From: Silvie Steiningerova
Sent: 25 August 2026 08:55
To: Planning.Responses
Subject: FW: 4 Regis Avenue, Bognor Regis - AW/138/26/HH.
Attachments: Prop Elevations 1.pdf

Please upload the attached plan to Planning, AW/138/26/HH, Substitute Plans, Proposed elevations- 04 Rev B, Public.

From: Chris Moore [REDACTED]
Sent: 24 August 2026 11:57
To: Silvie Steiningerova <Silvie.Steiningerova@arun.gov.uk>
Subject: 4 Regis Avenue, Bognor Regis - AW/138/26/HH.

PROPOSED ELEVATIONS

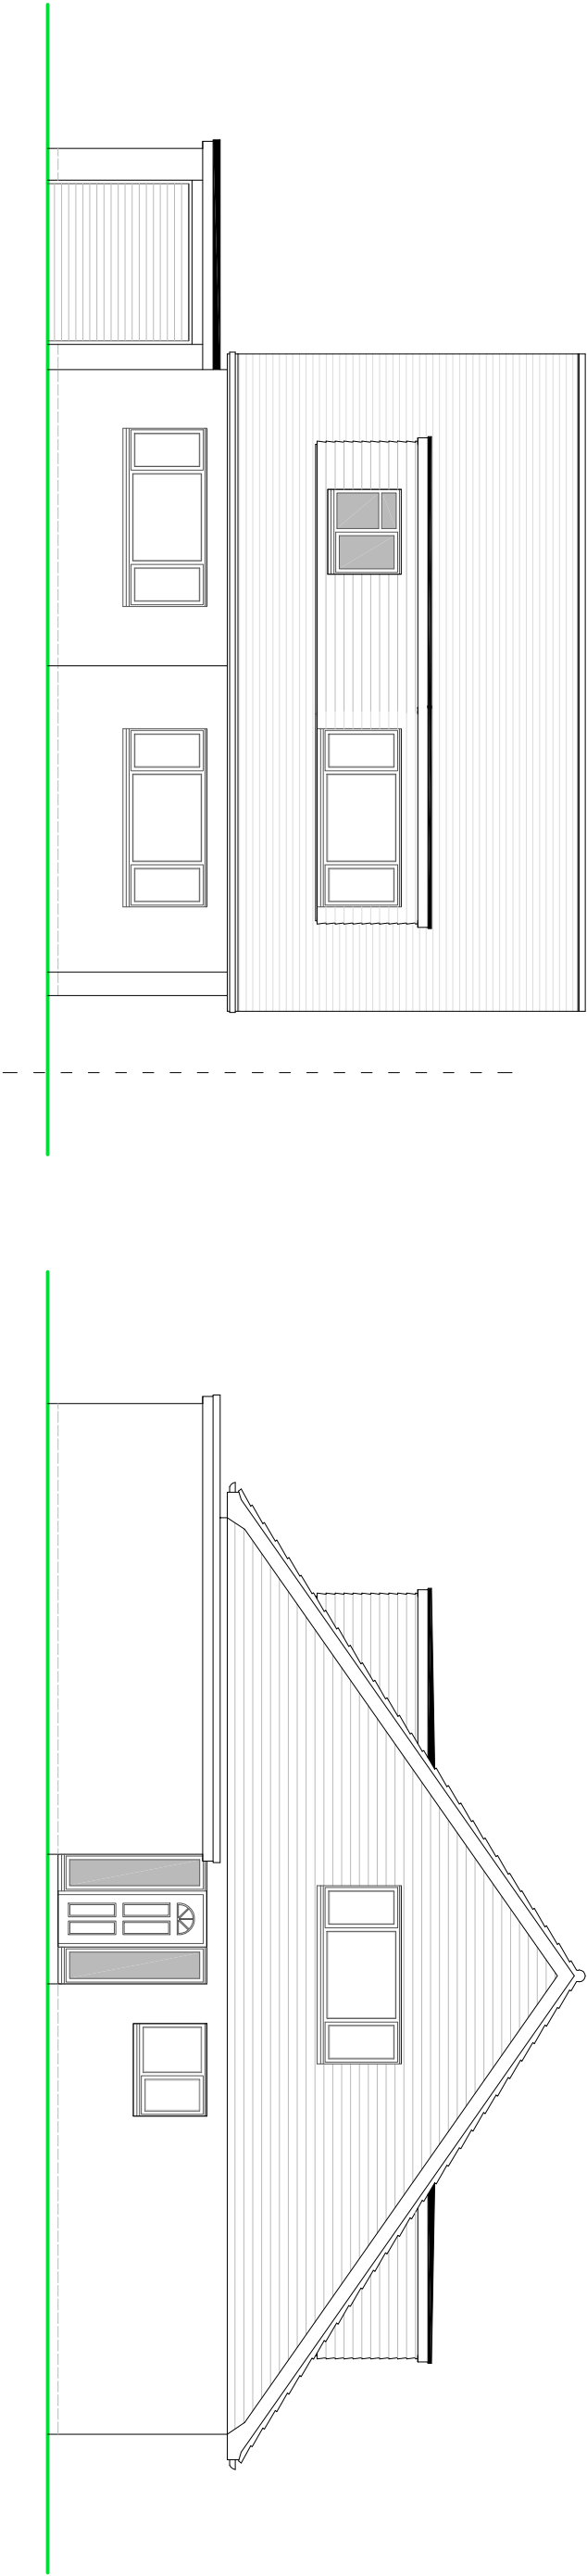
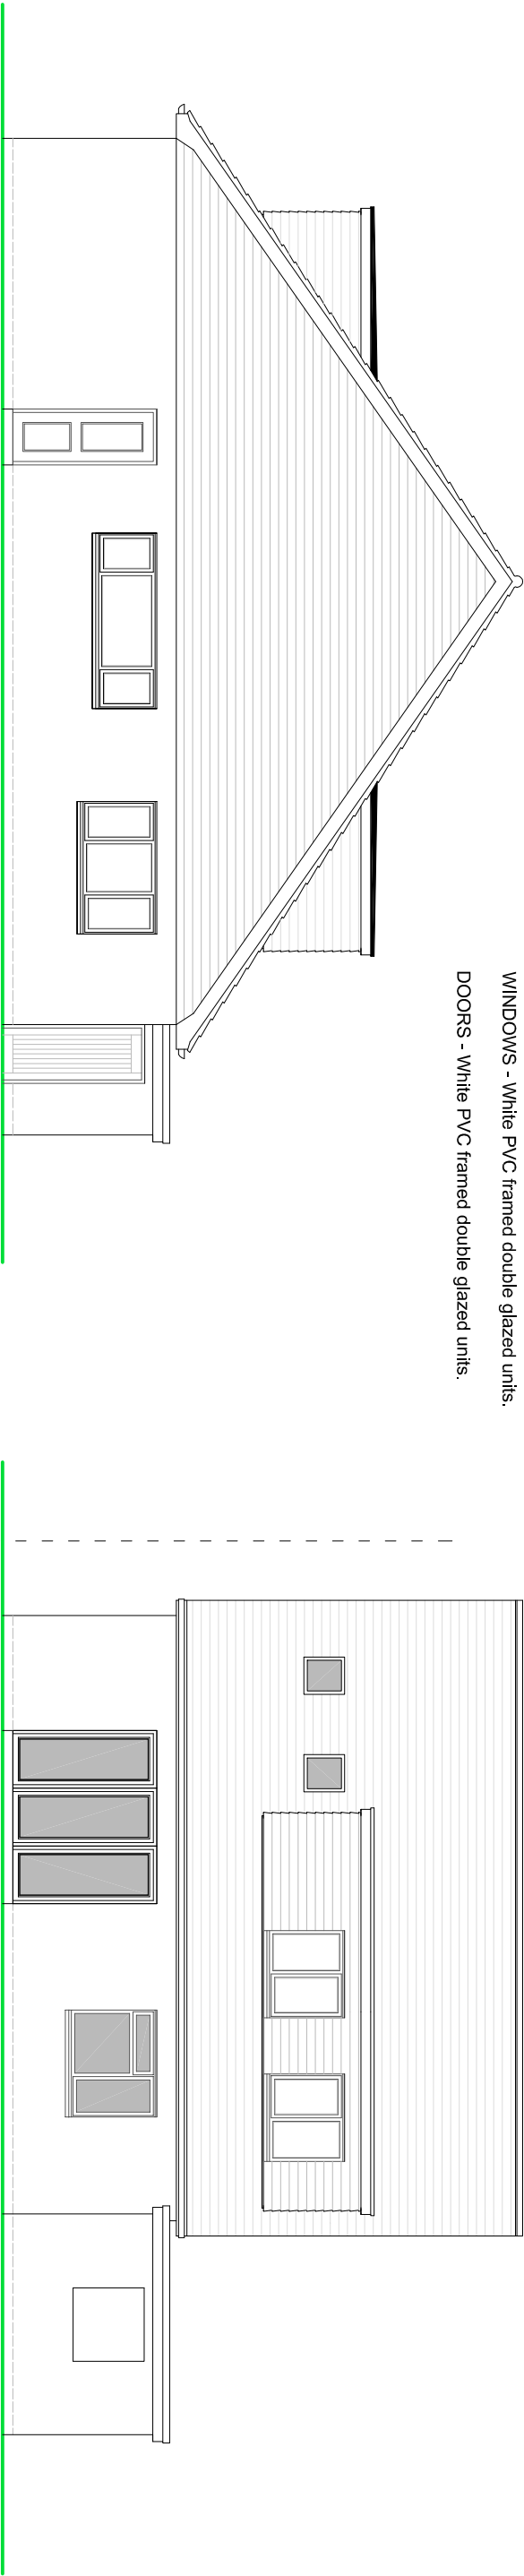
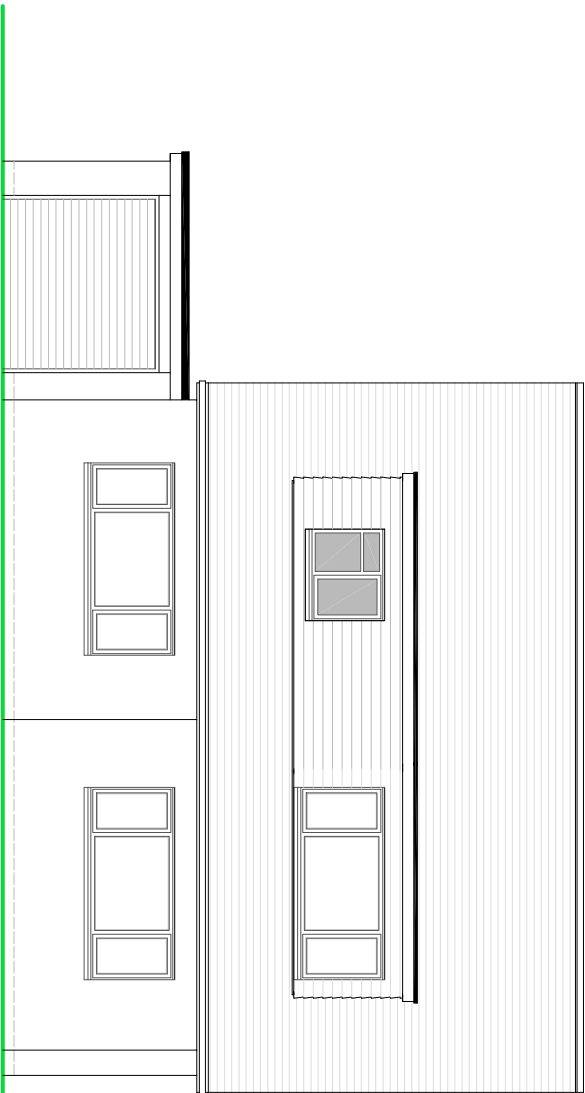
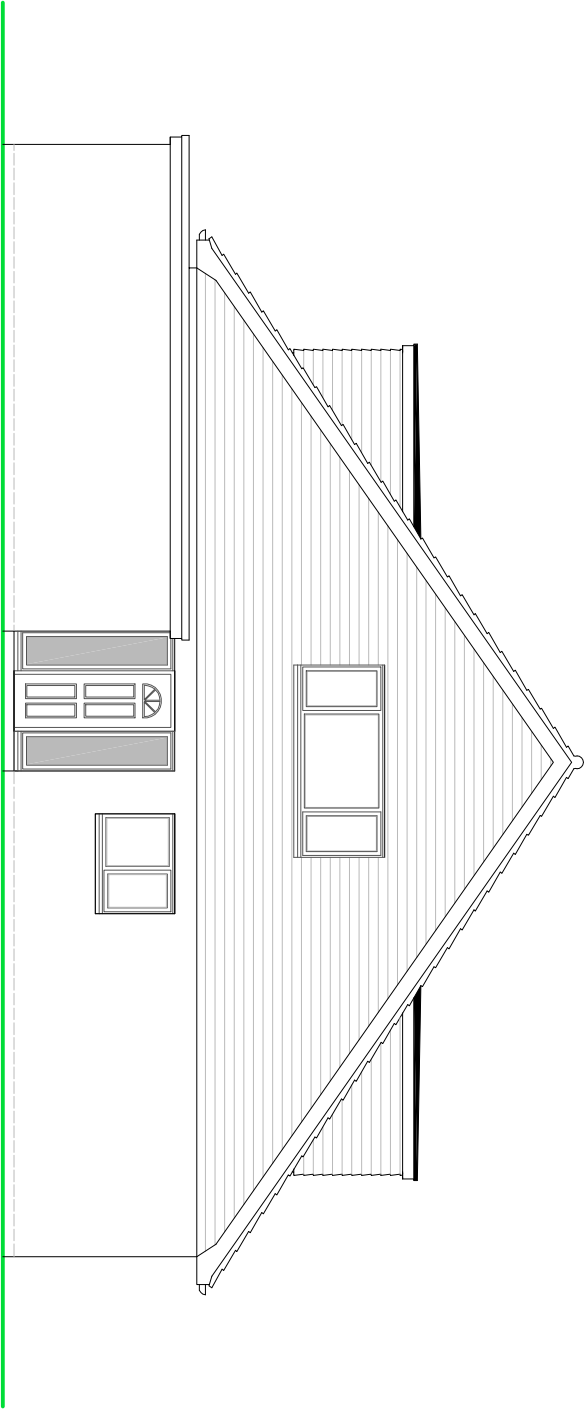
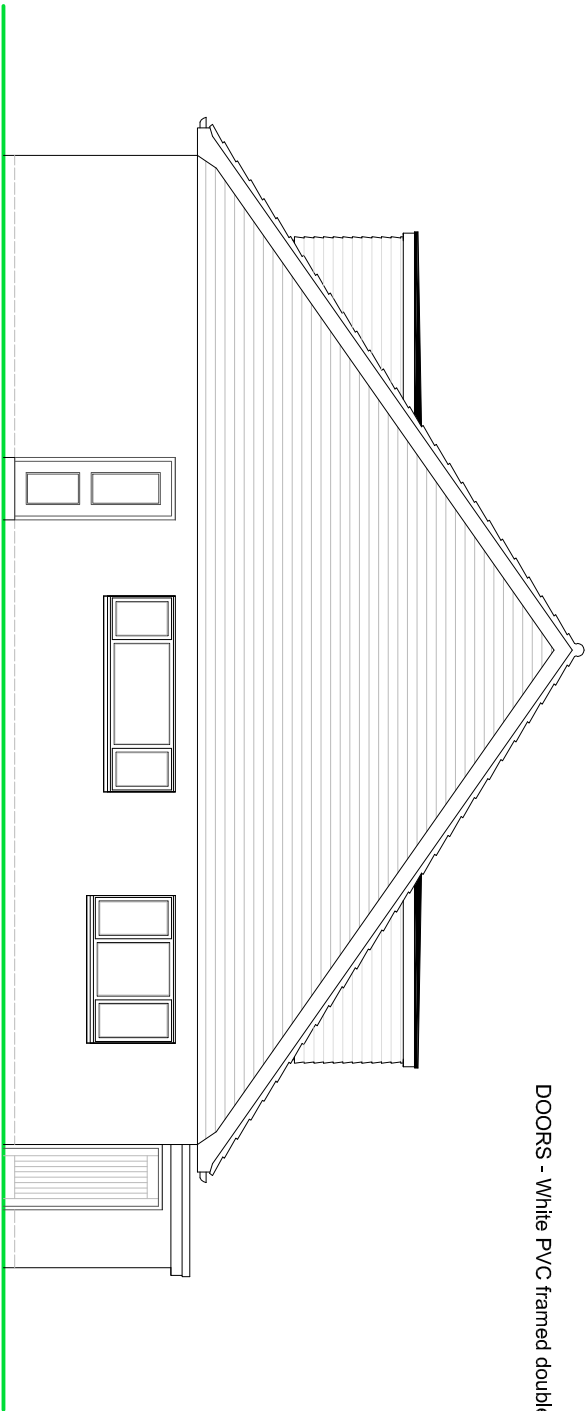
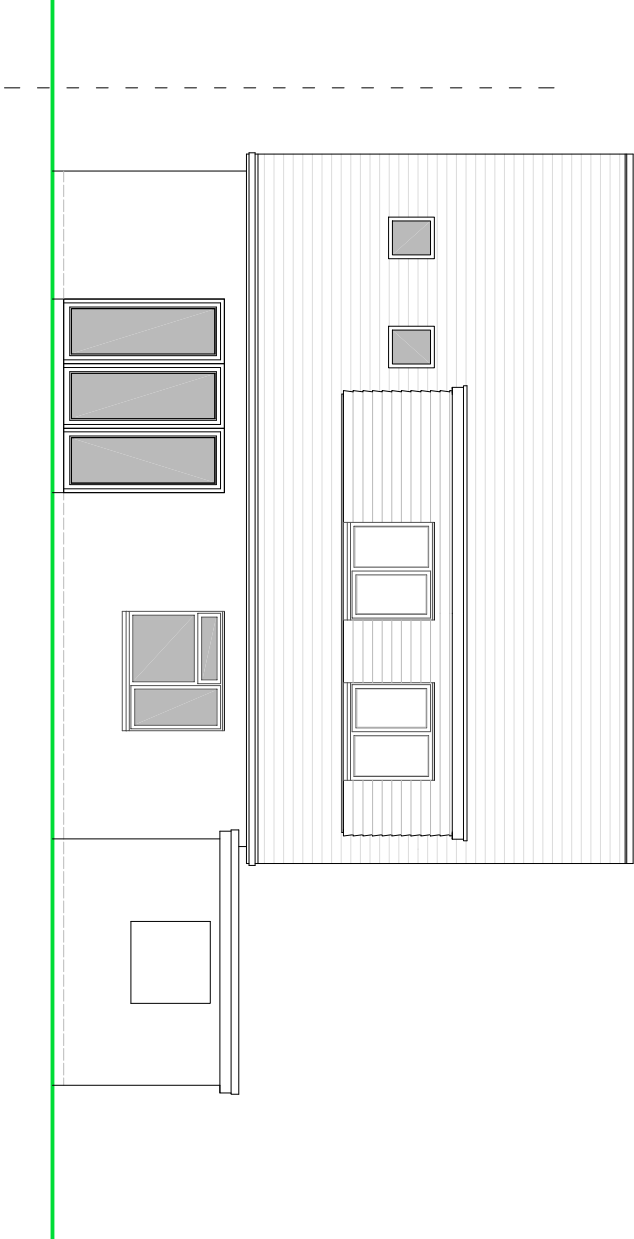
We have found out that we need to re-roof the property and have taken the opportunity to change the roof tile to one which is more suitable for the exposed location.

I therefore attach a copy of the revised proposed elevations showing the change to a 'Marley Modern' tile – please can this be considered within the application?
